MODIFICATION REQUEST:

Building C, Walker Street, Rhodes

MP 10_0105 MOD 5

Modification to rooftop to provide a private garden

Drawing Name:
Level 20 Plan

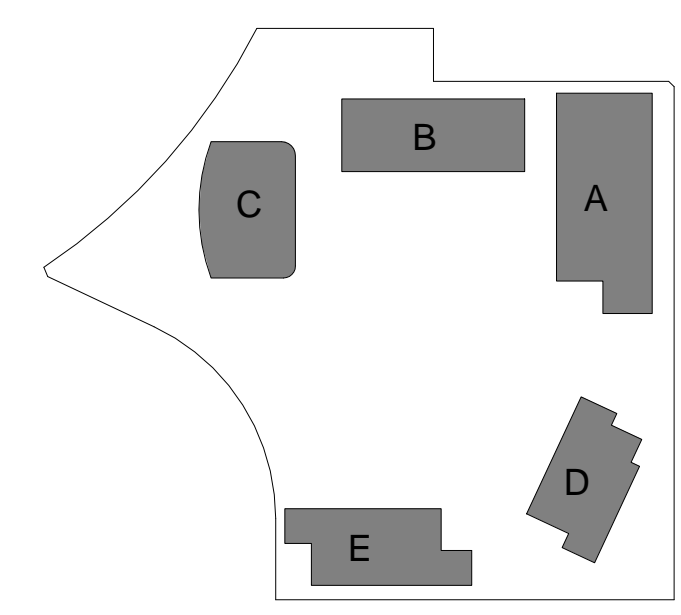
The proposal seeks to modify the rooftop of Building C through providing a private rooftop garden. In particular, the proposal includes:

- the construction of a timber deck with a pergola on the western side of the roof;
- replacement of the concrete and gravel finish on the roof with astro turf;
- planting in designated areas; and
- reconfiguration and extension of the plant and lift overrun to include a stairwell (where the unit owners will gain access to the rooftop), toilet and maintenance store.

Noting the above, the department considers that the proposal does not impact on the approved bulk and scale of the building and therefore the proposed modifications are supported.

**3 ELEVATION**  
BLDG C - WEST  
1 : 200

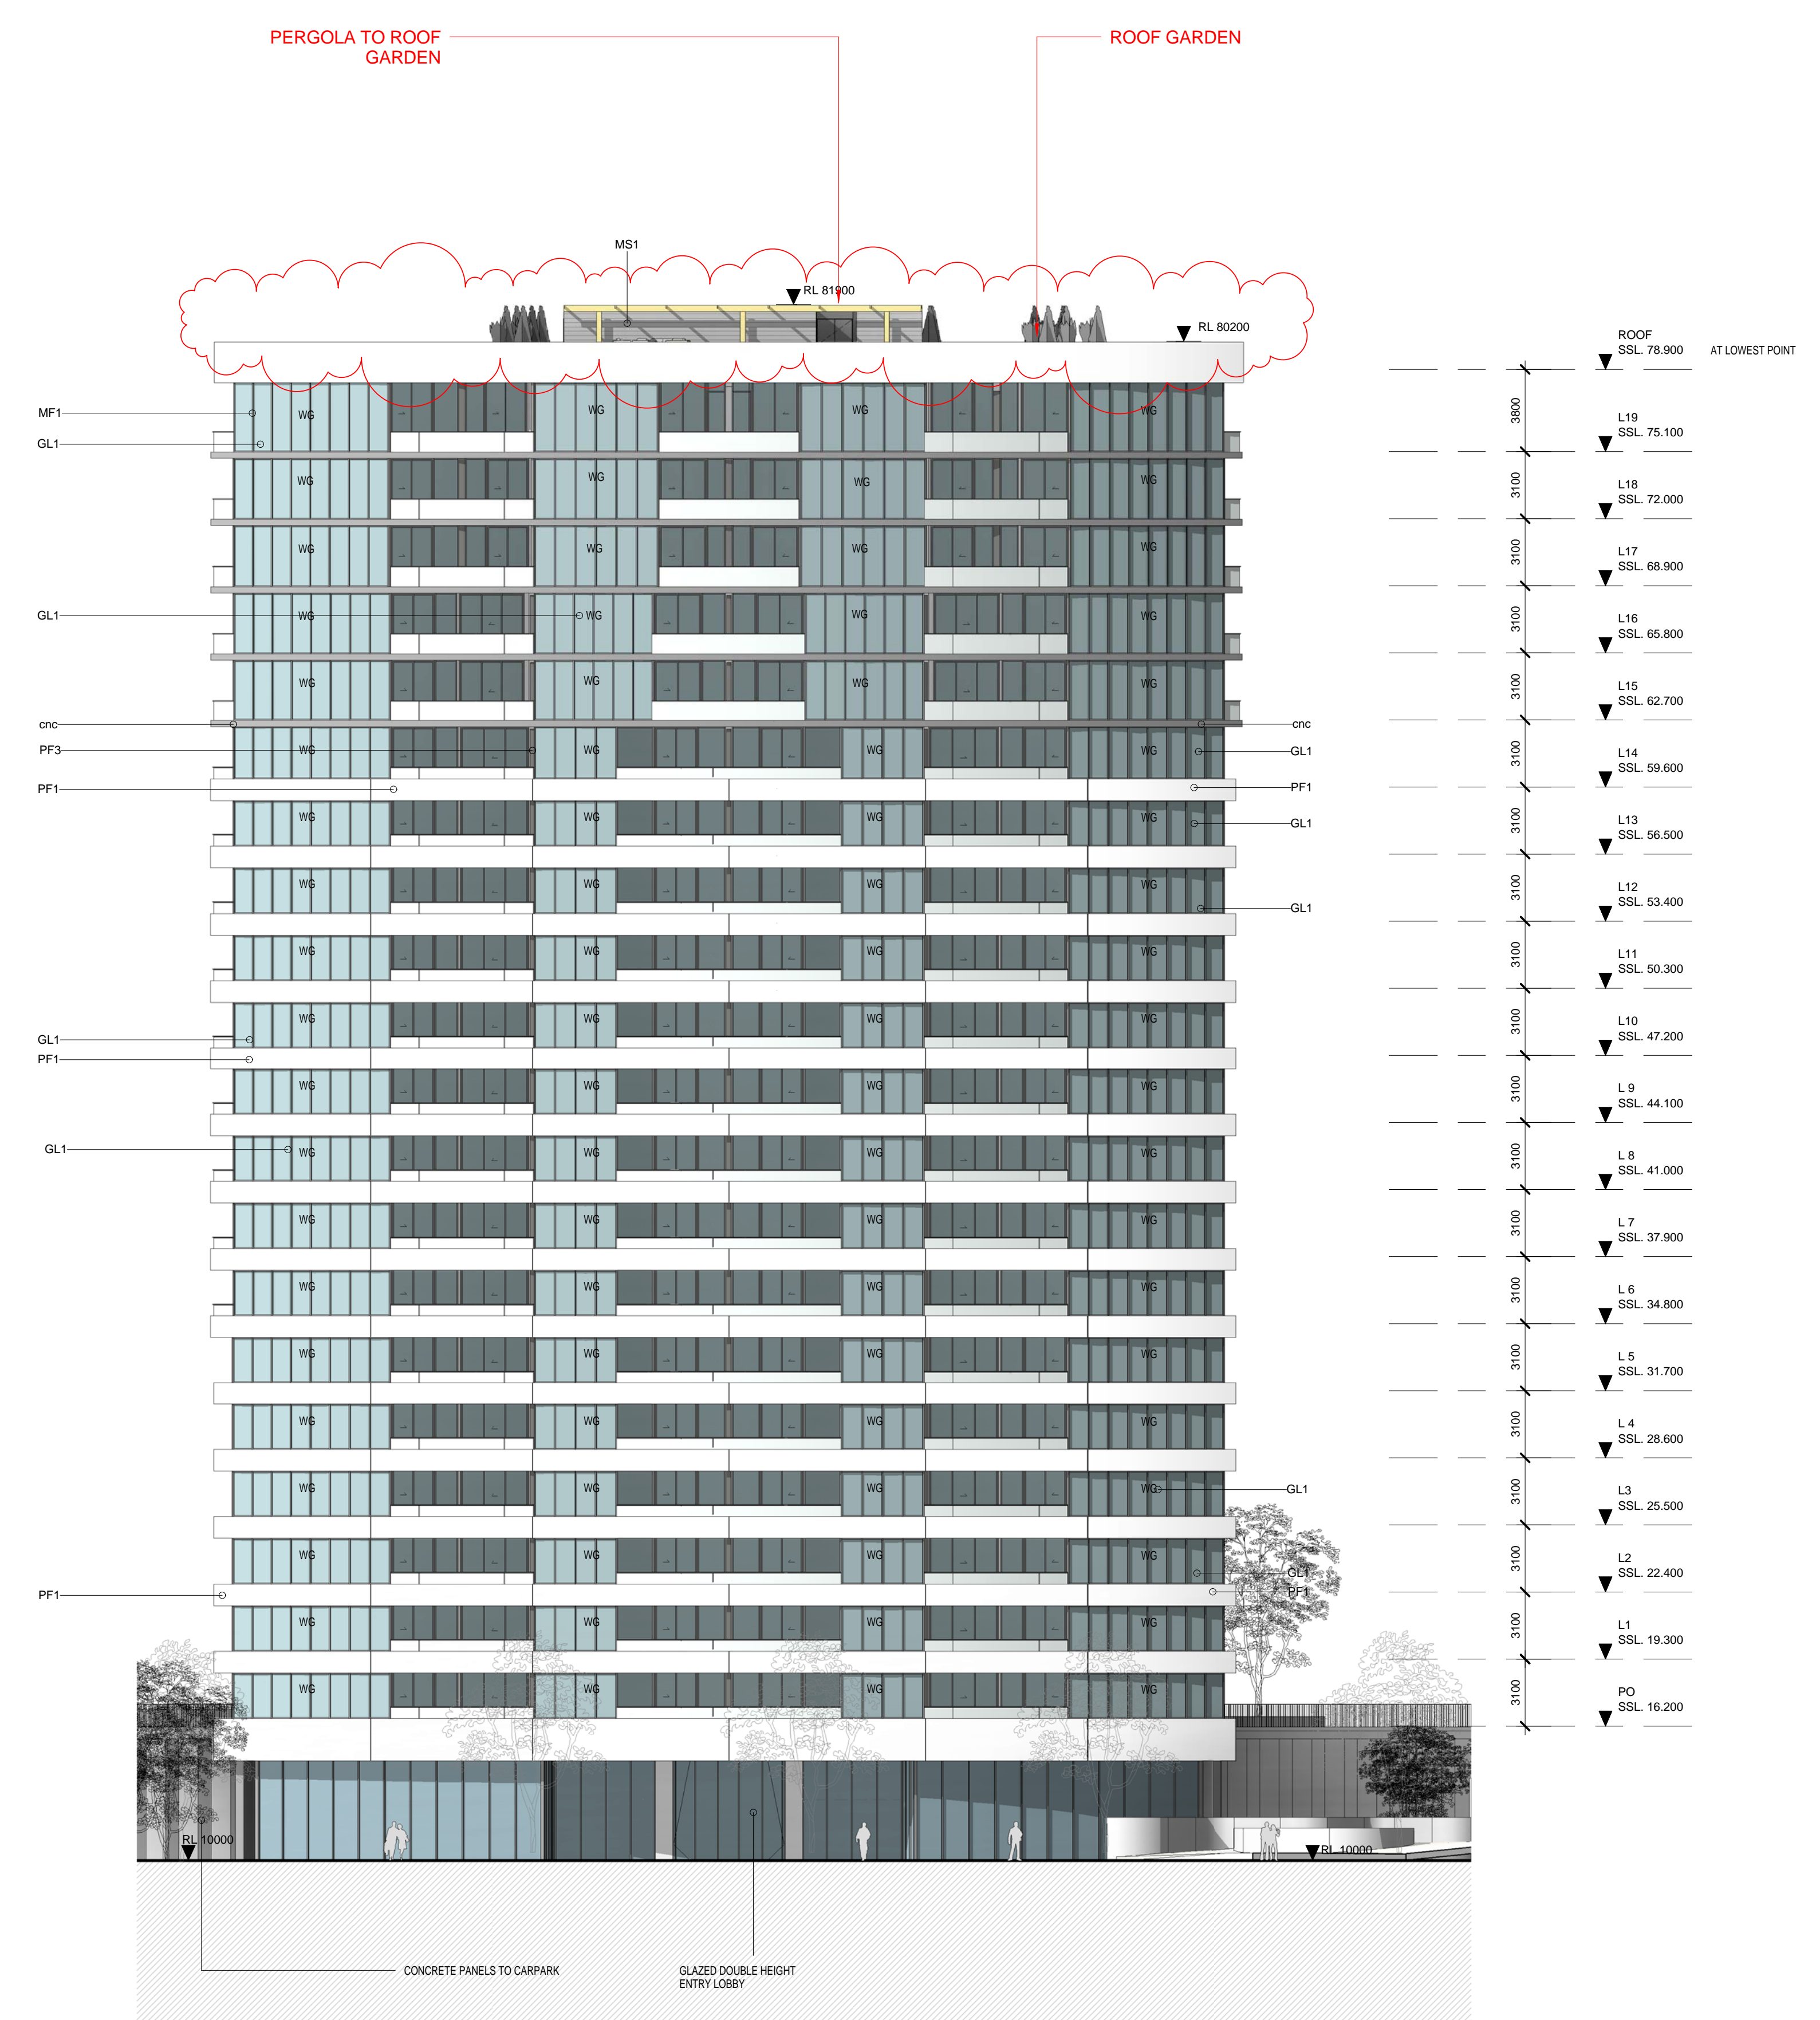
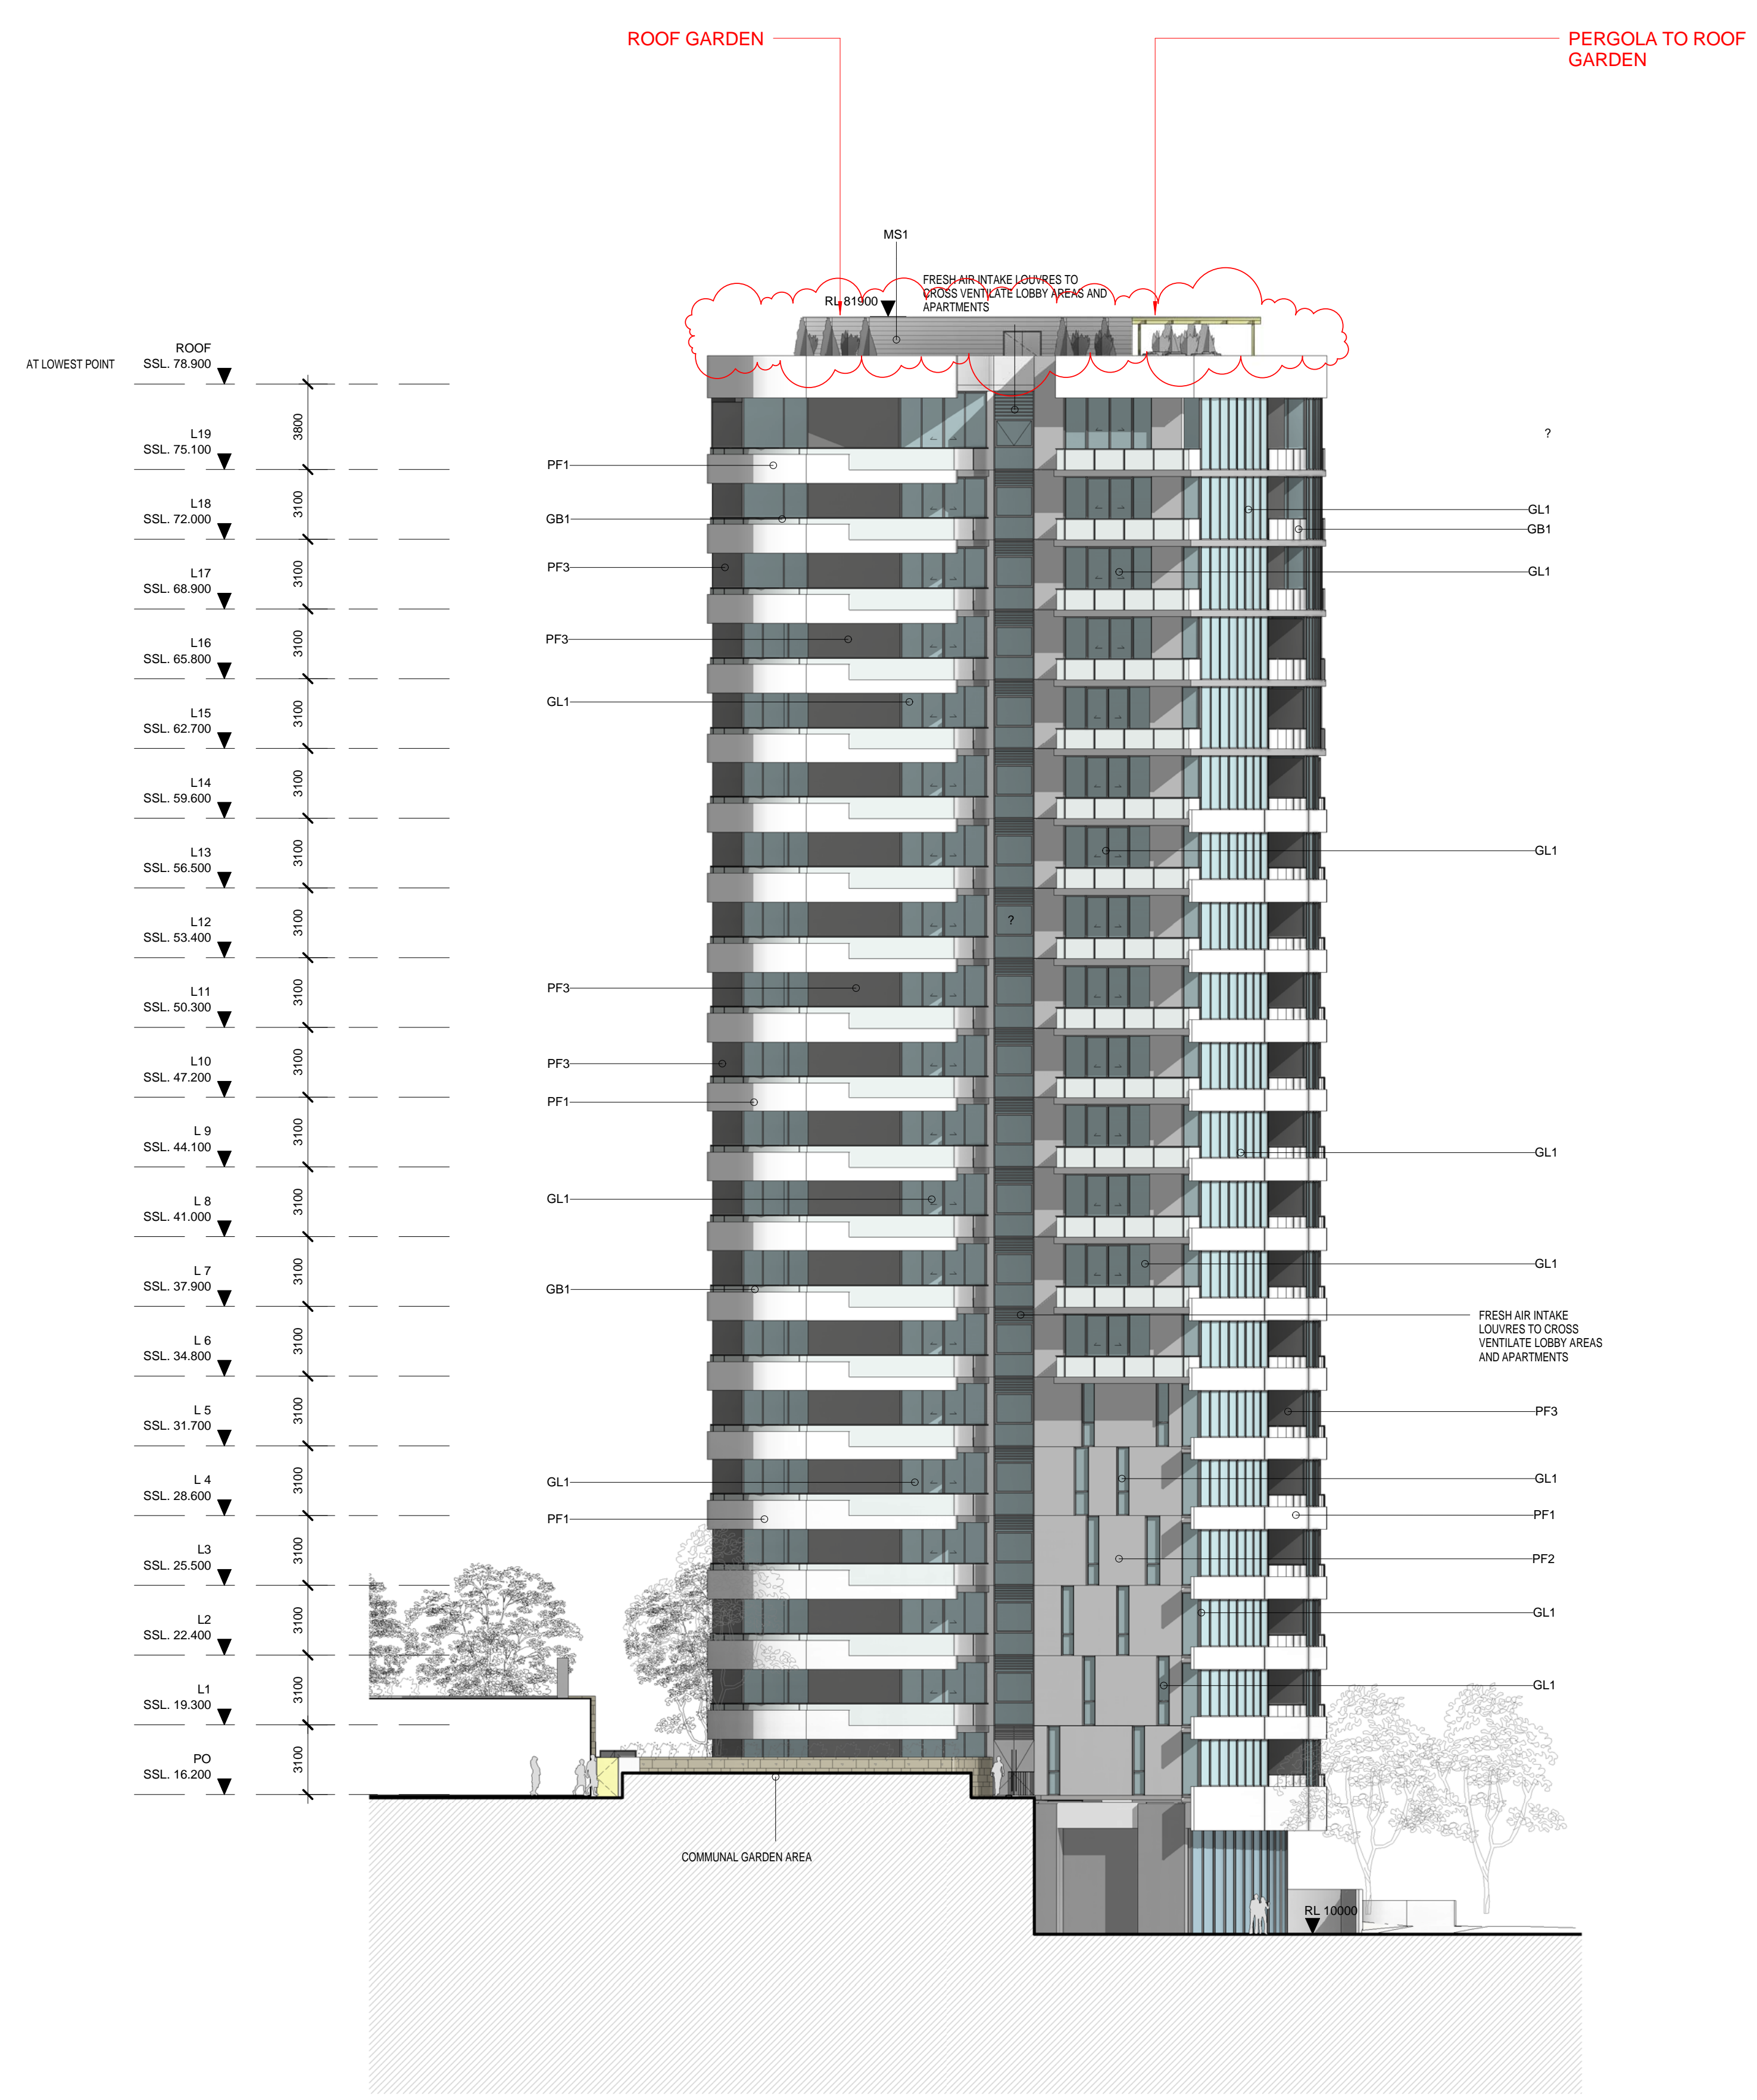
As a consequence of the above amendments, the exterior appearance of the approved rooftop plant area is modified (**Figure 4**). The overall height of the building and plant is maintained, however the modifications to the plant and lift overrun, new pergola and landscaping, will alter the visual appearance of the rooftop of the building when viewed from neighbouring buildings.

Notwithstanding, the department considers that the overall visual impact will be improved. The introduction of landscaping and a pergola will assist in screening and minimising the visual dominance of the roof top plant and lift overrun.

As the overall height is unchanged and the plant/lift overrun and pergola is setback from the building edge, the proposal will not result in any additional overshadowing impacts.
